1st REVIEW – FIRE DEPARTMENT CONSTRUCTION REVIEW
APPROVED WITH COMMENTS

CIMARRON HILLS FIRE PROTECTION DISTRICT – (CH2017-20-CN-1)

June 20, 2017

On Monday, June 19, 2017 the Cimarron Hills Fire Department submitted construction plans to PEAK Consulting Services, Inc. for a fire code compliance review for the **NEW HAMMERS SPEC OFFICE/WAREHOUSE BUILDING** located at **7190 Cole View** in the CIMARRON HILLS FIRE PROTECTION DISTRICT. This plan is for a 5,000 square foot building with Type IIB construction and B/S1 occupancy. This project has been submitted and reviewed under the provisions of the 2009 IBC/IFC as amended by the Cimarron Hills Fire Protection District.

1 SITE PLAN
SCALE: 1"=20'-0"

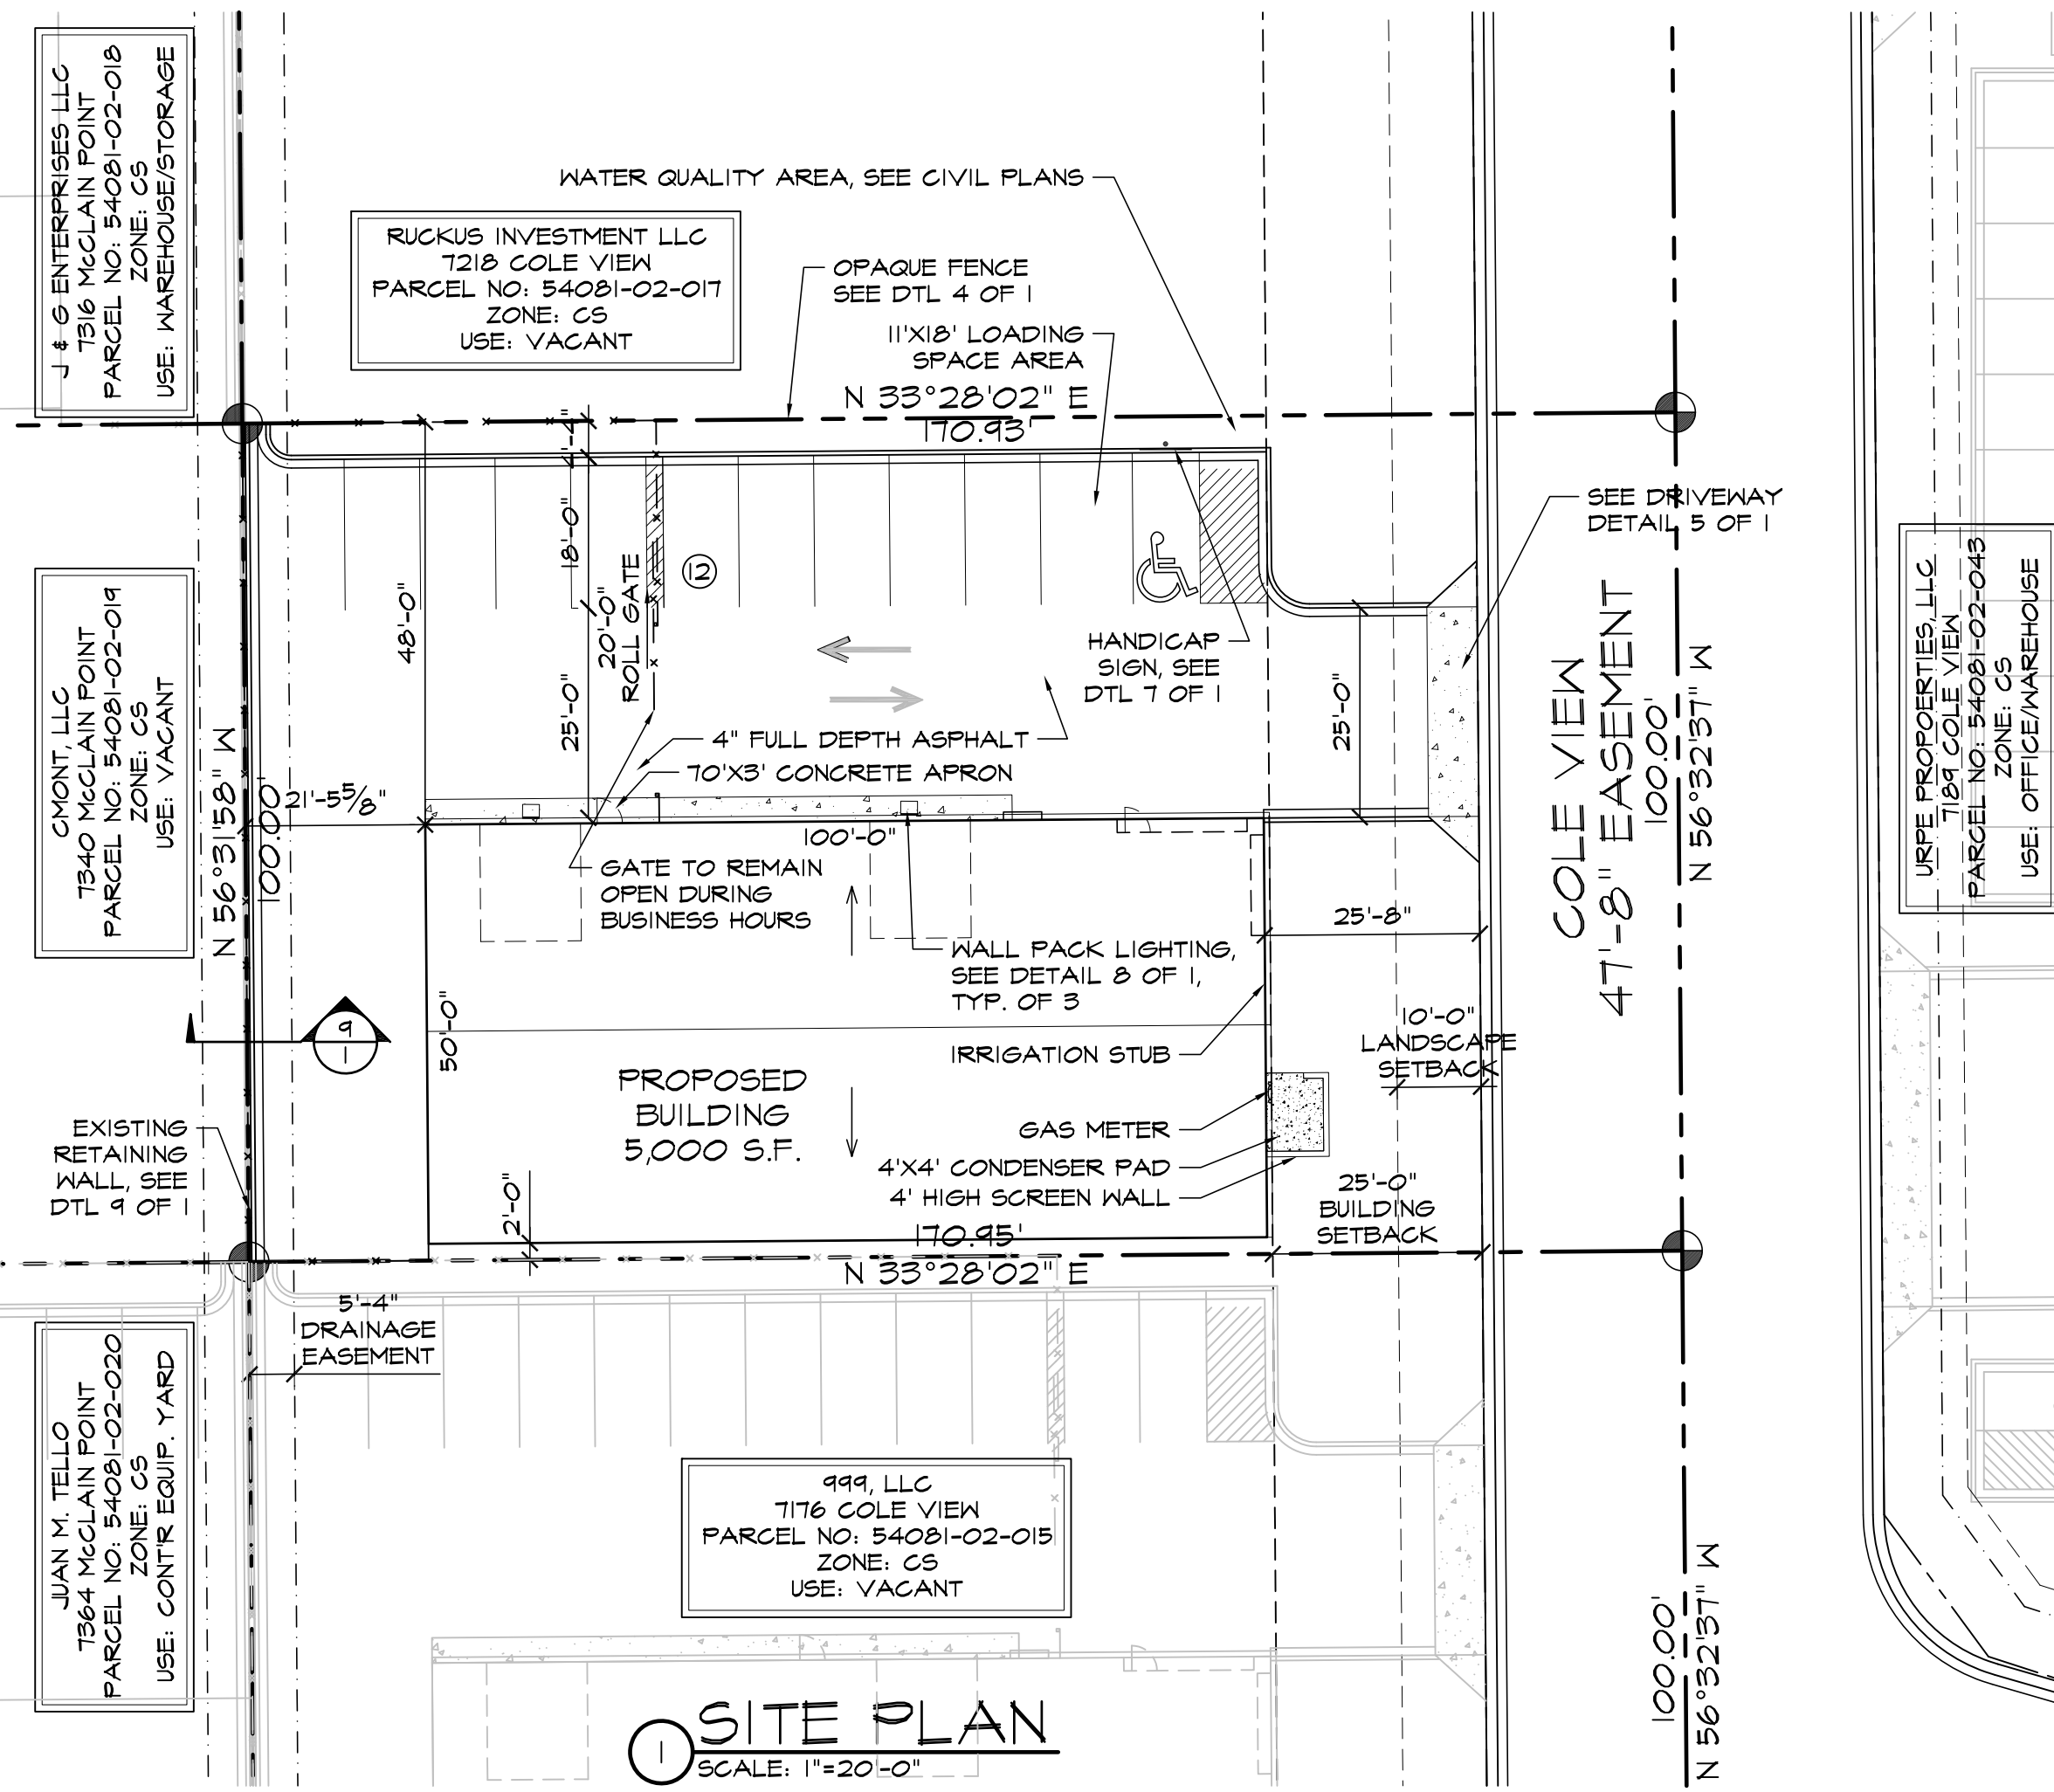
GATE – Be advised the property access gate will need to be equipped with an electric knox switch, a knox padlock, or a gate key will need to be installed in the building Knox box. Please call if you have questions.
